**REQUEST**

Current Zoning: UMUD-O (uptown mixed-use district, optional)  
 Proposed Zoning: UMUD-O SPA (uptown mixed-use district, optional, site plan amendment)

The petition proposes to allow up to three electronic changeable copy signs totaling a maximum of ~~5,900~~ **4,800** square feet. The site is developed with a mixed-use office tower.

Stonewall Tower Development, LLC

1 SITE PLAN - SIGNAGE LOCATOR MAP
 1" = 40'-0"

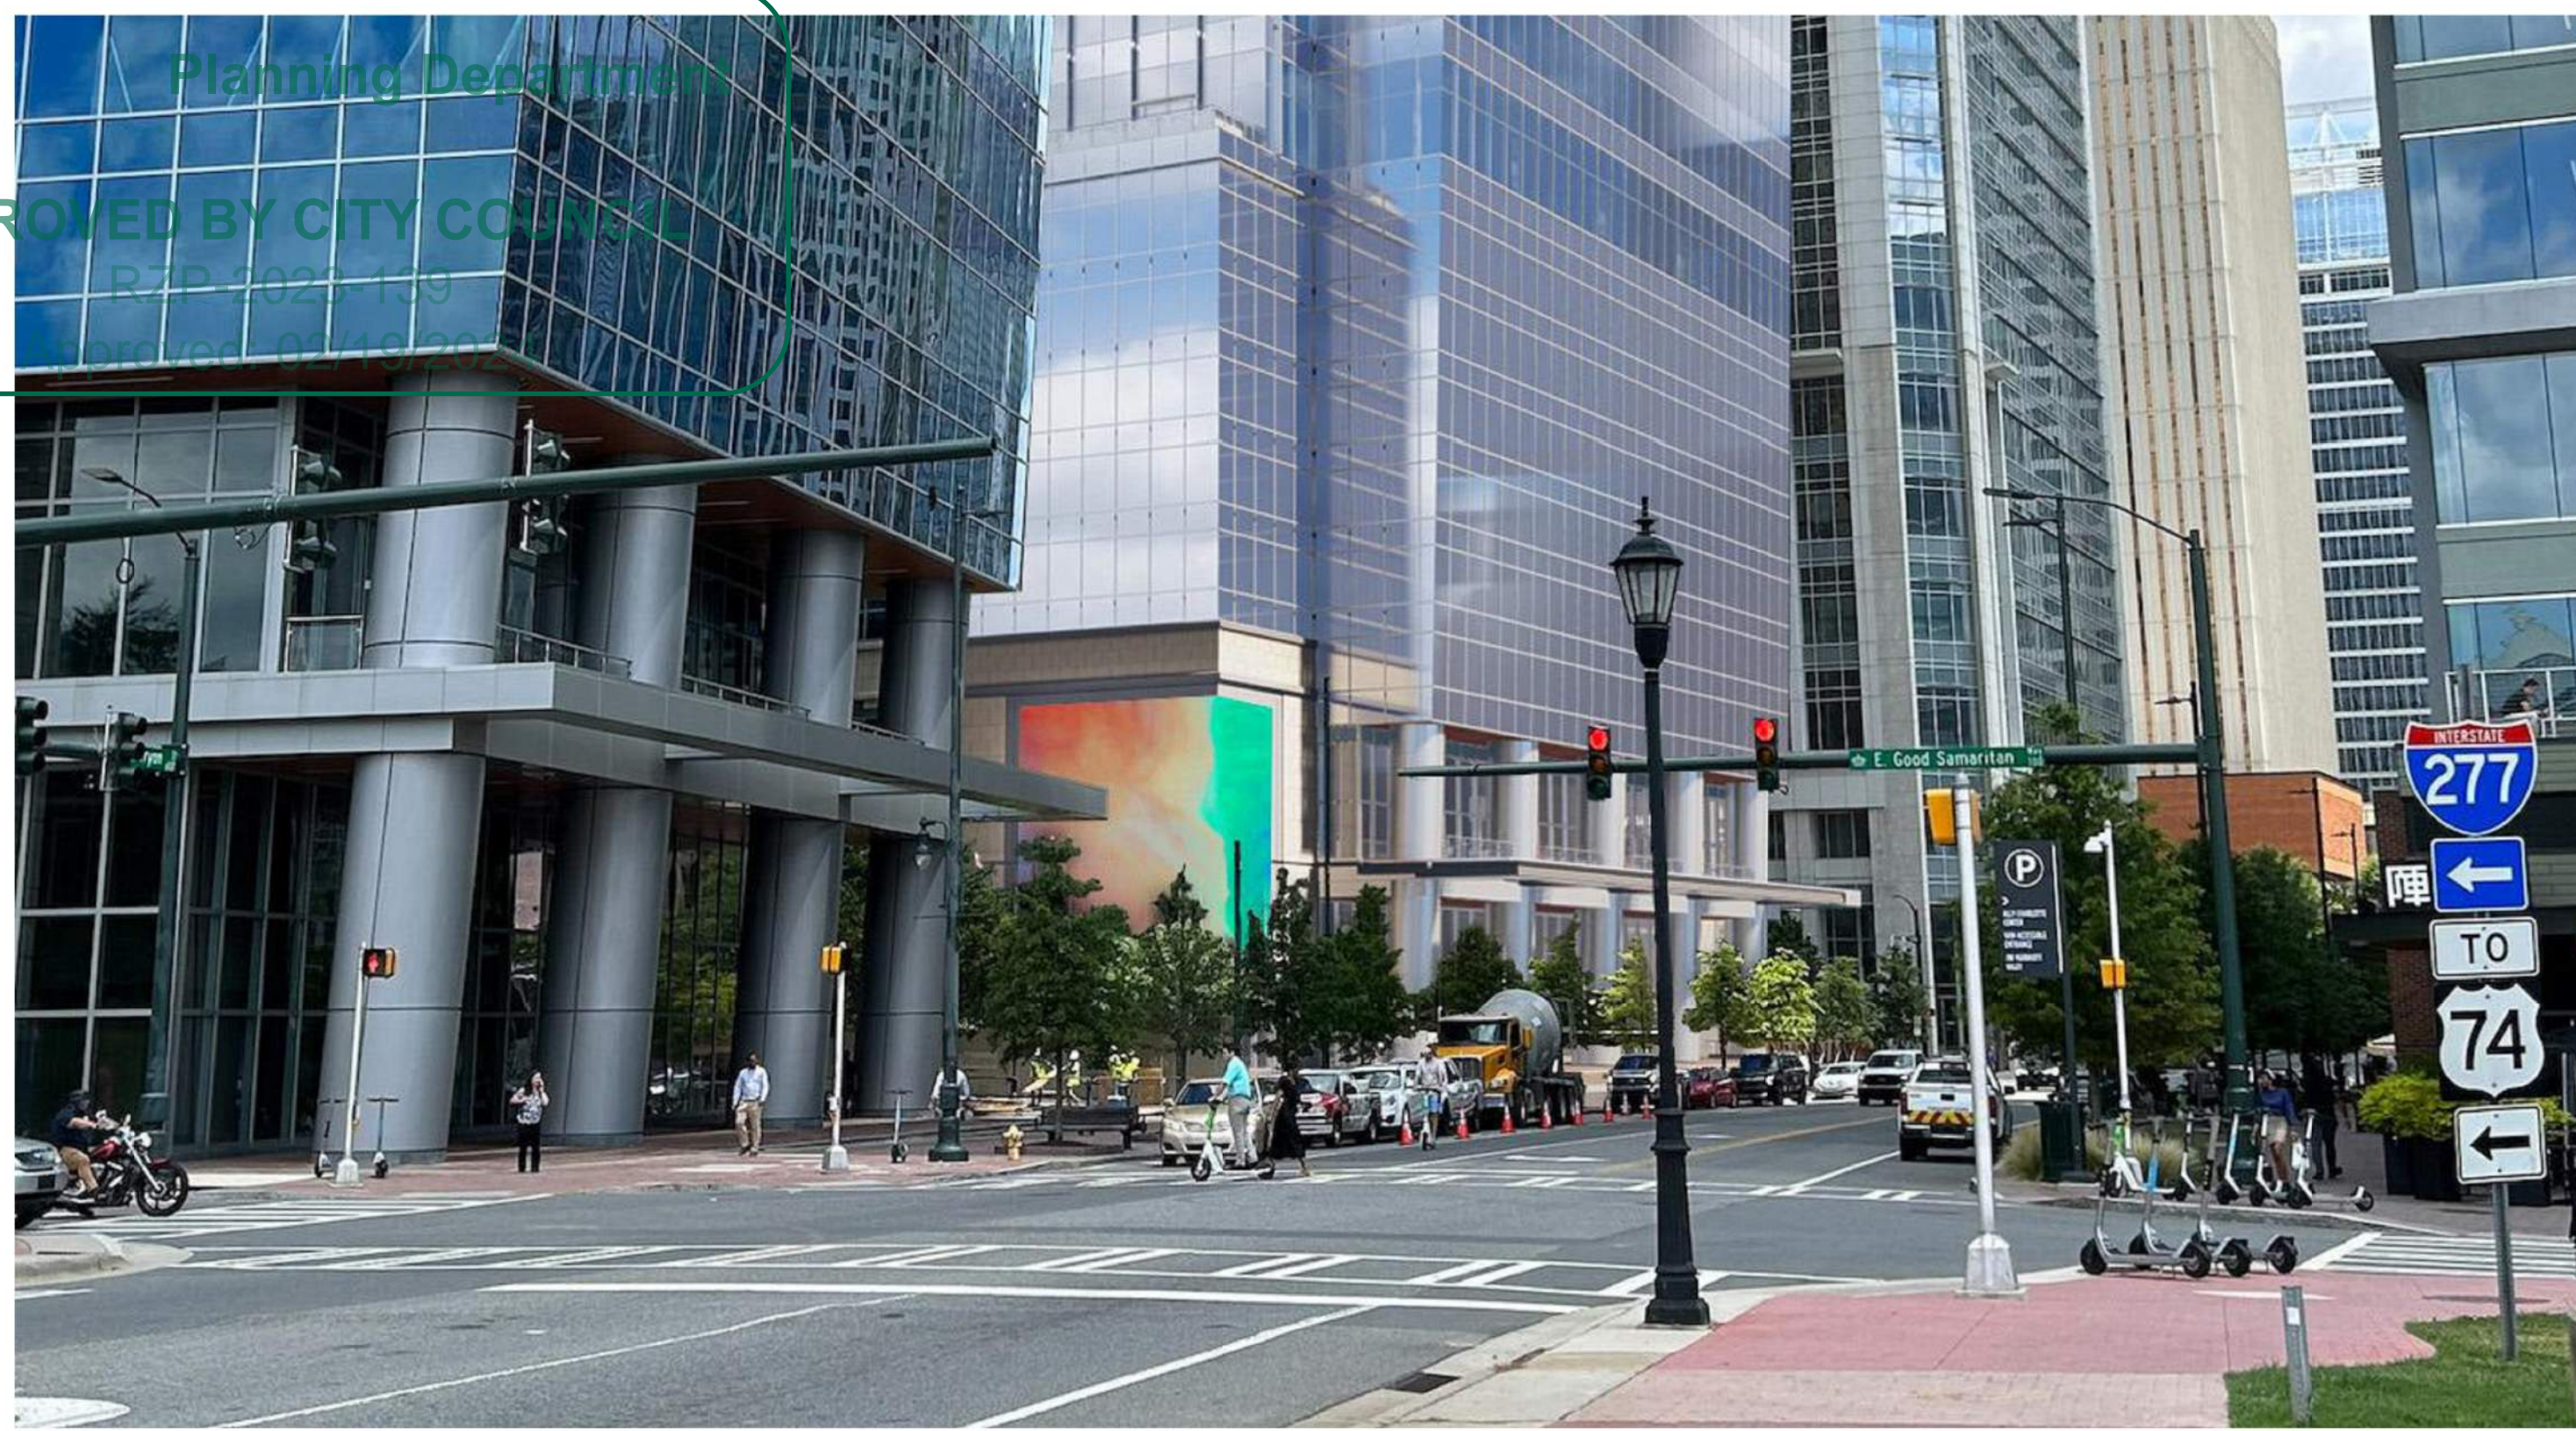
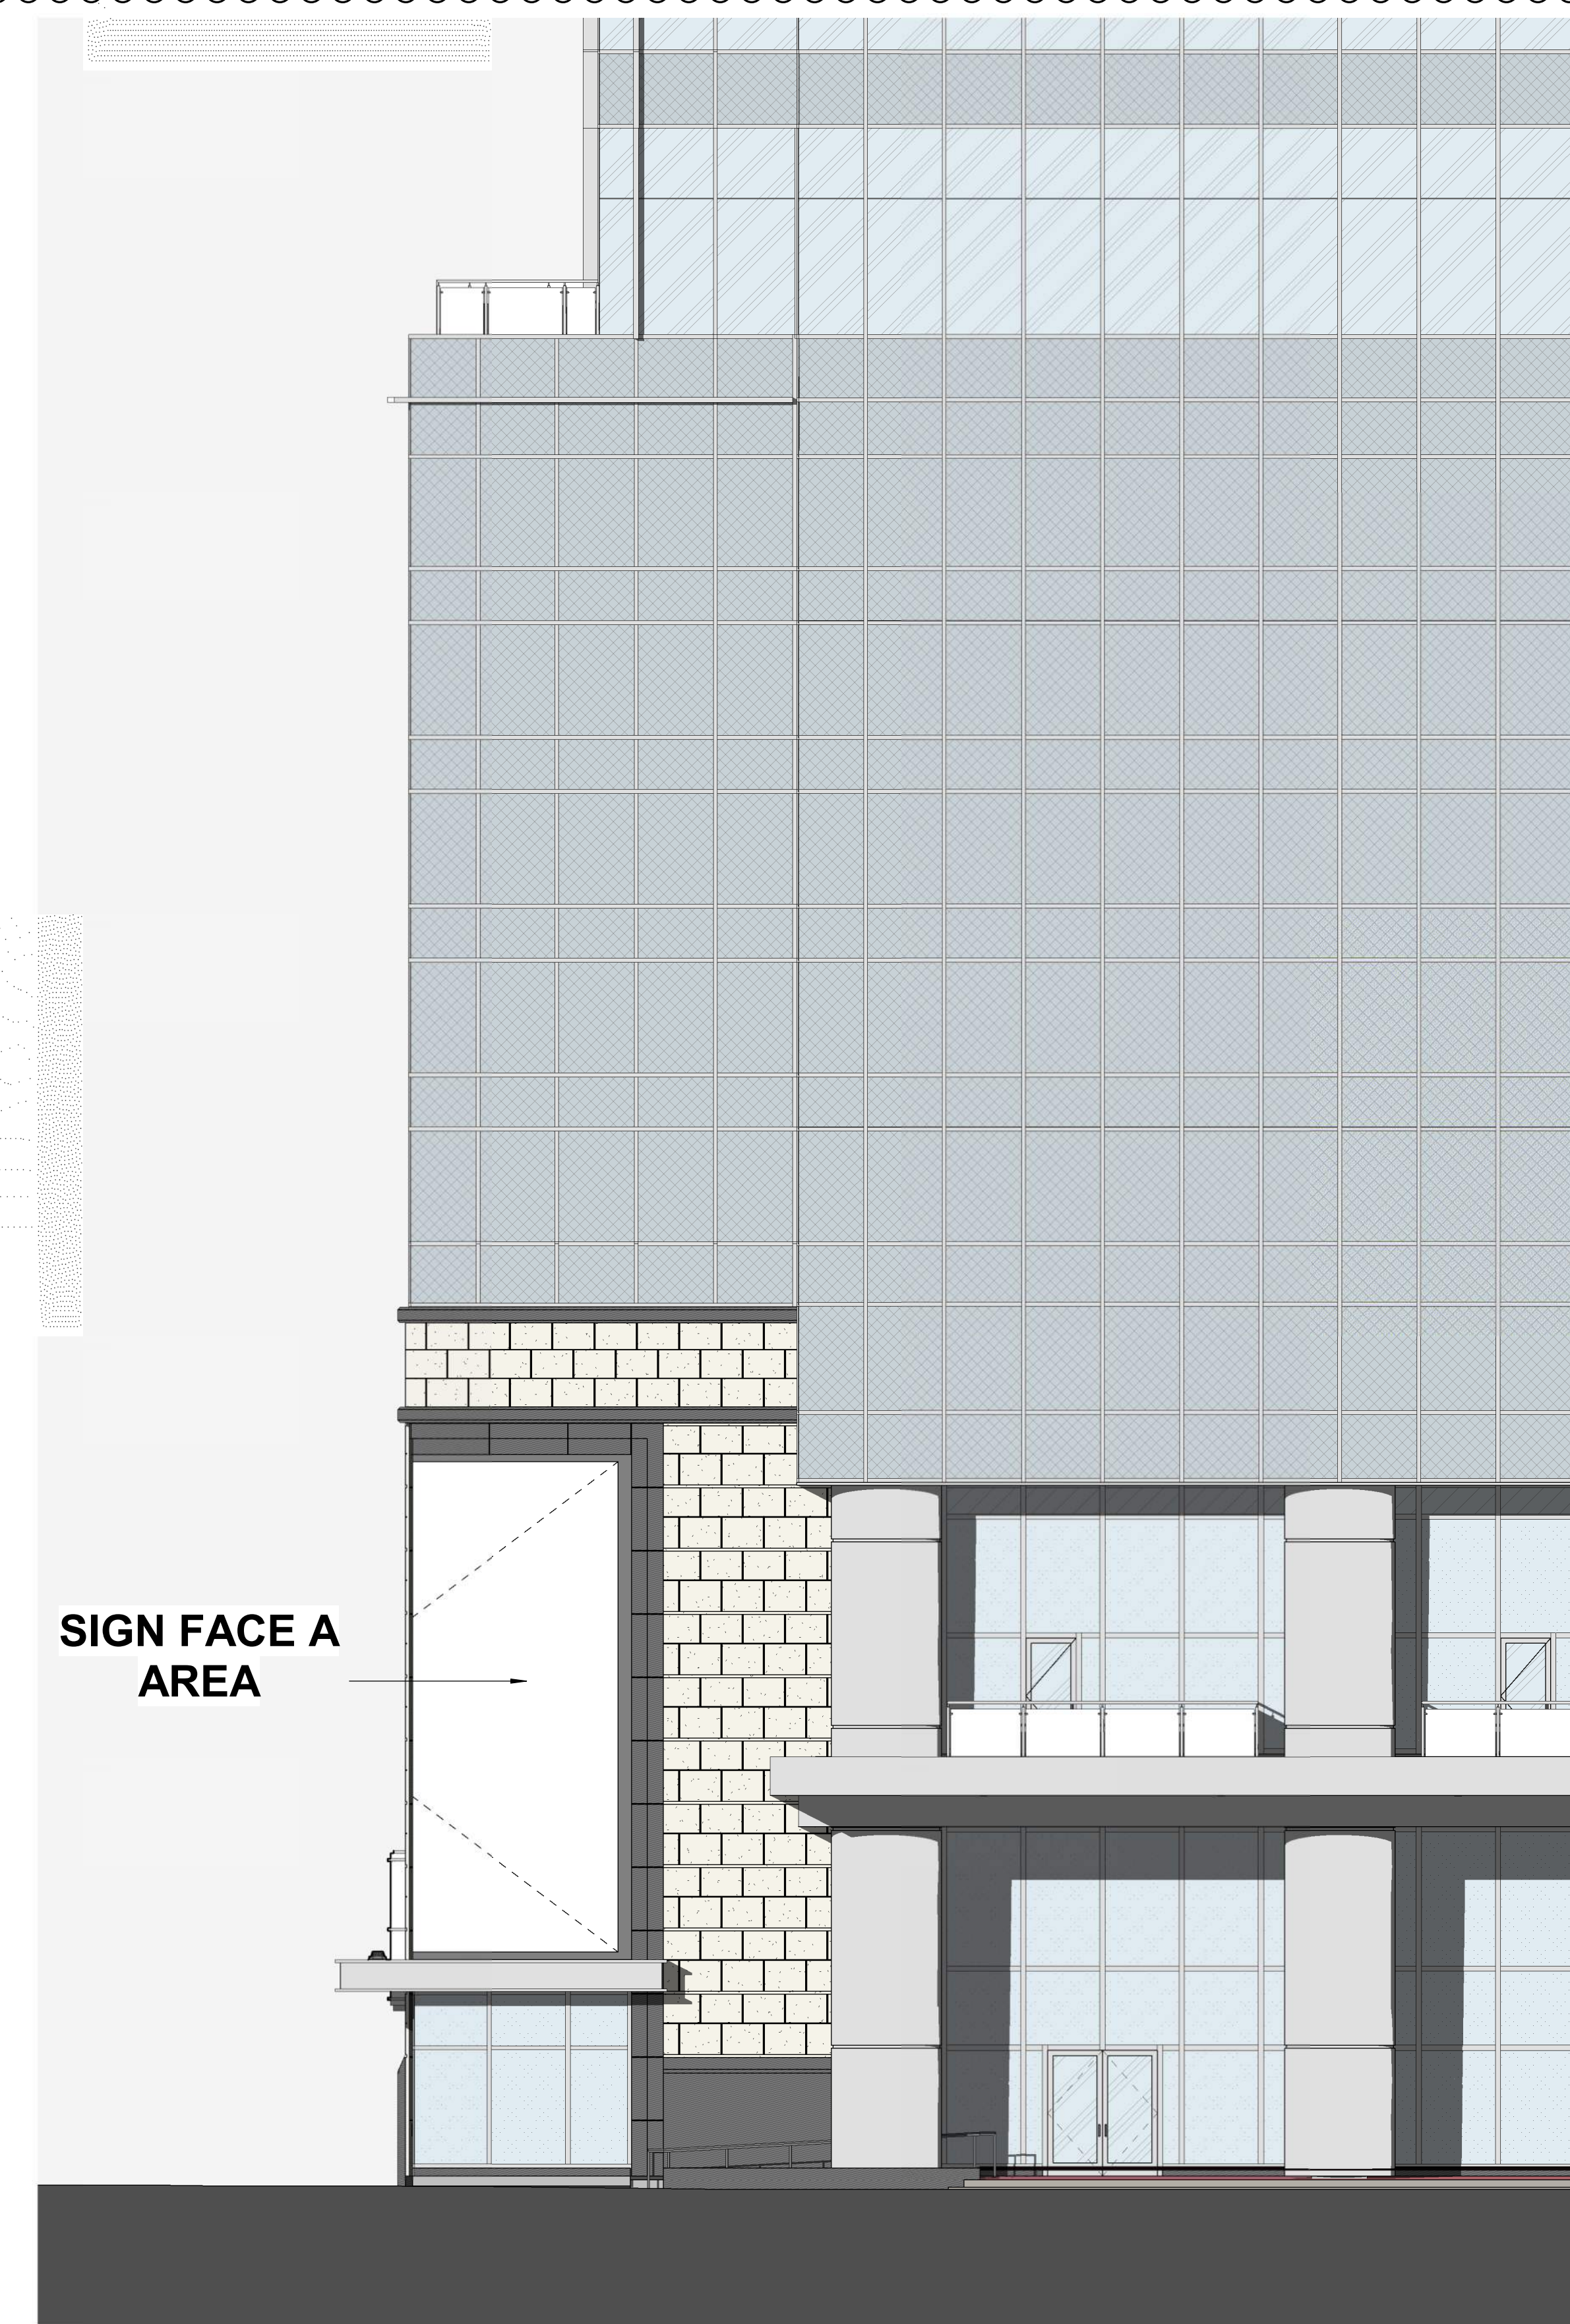
- ~~1. The language of the proposed optional provisions should be updated to describe the requested signage as wall signs in accordance with the standards Chapter 13 of the Zoning Ordinance.~~

**ADDRESSED**

SIGN LOCATION #2 - TRYON STREET AND BROOKLYN VILLAGE AVE CORNER = 1,400 SF

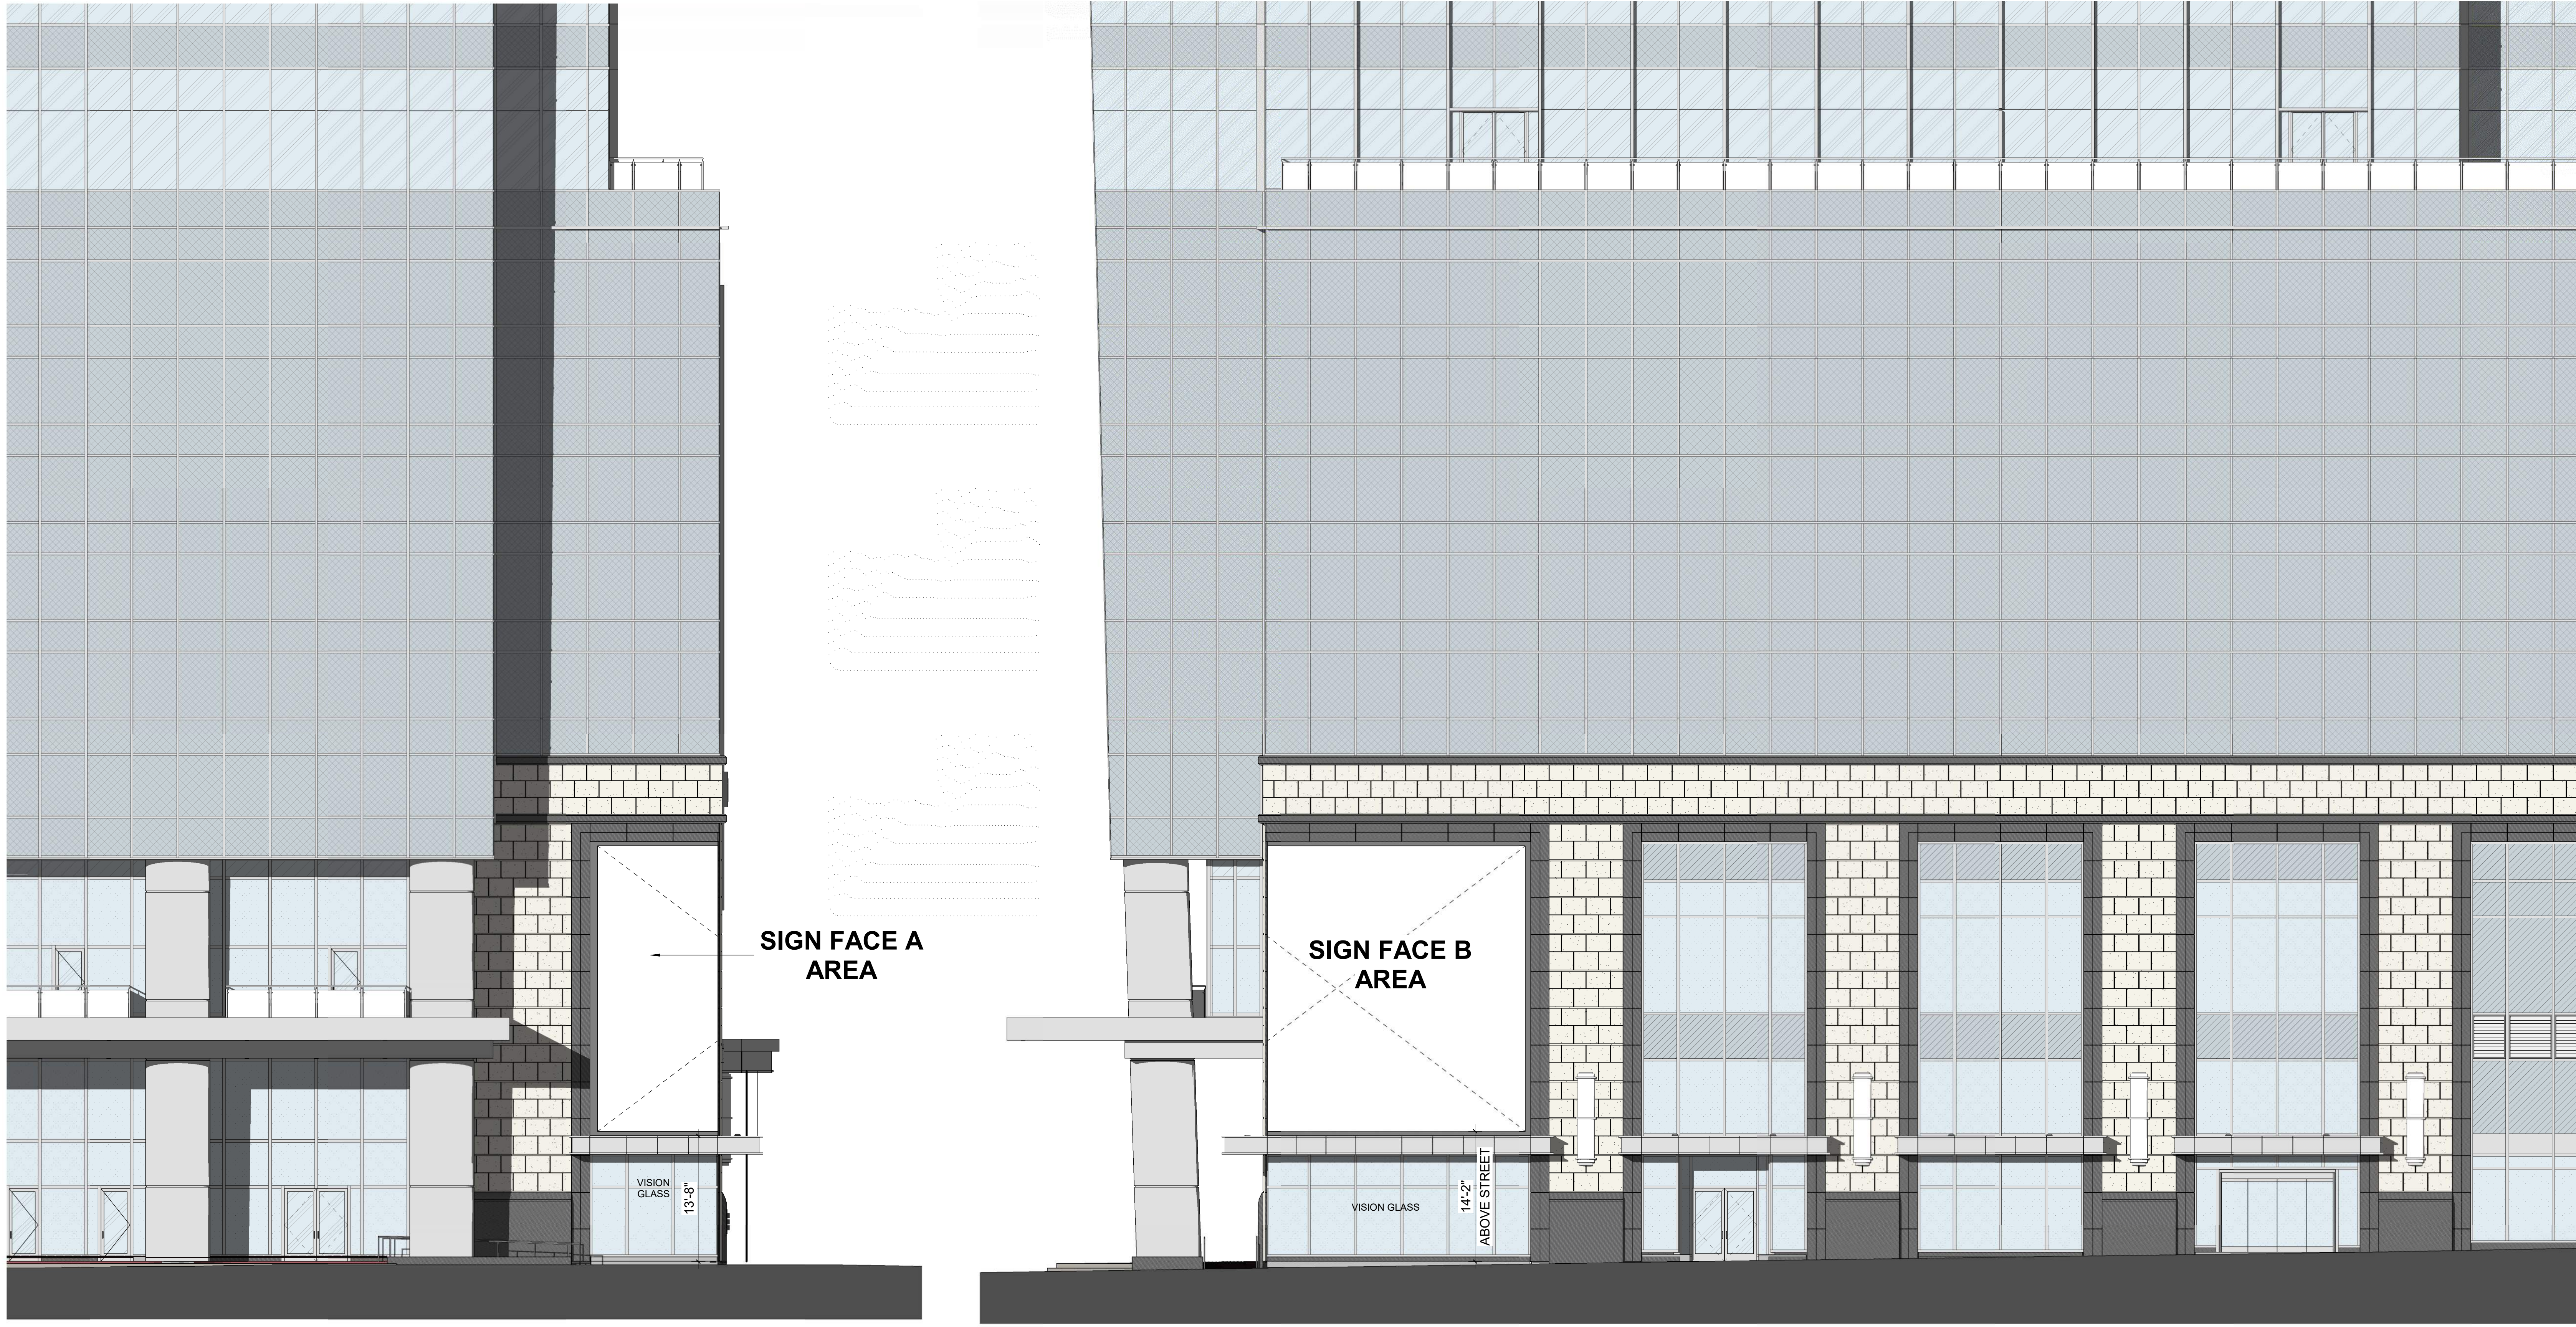
- Proposes to allow up to three electronic changeable copy signs totaling up to ~~5,900~~ 4,800 square feet.
  - Sign 1 at the site’s Tryon Street Plaza is proposed to be 1,400 square feet.
  - Sign 2 at Tryon Street and Brooklyn Village Avenue is proposed to be 1,400 square feet.
  - Sign 3 at Brooklyn Village Avenue and Church Street is proposed to be ~~3,100~~ 2,000 square feet.
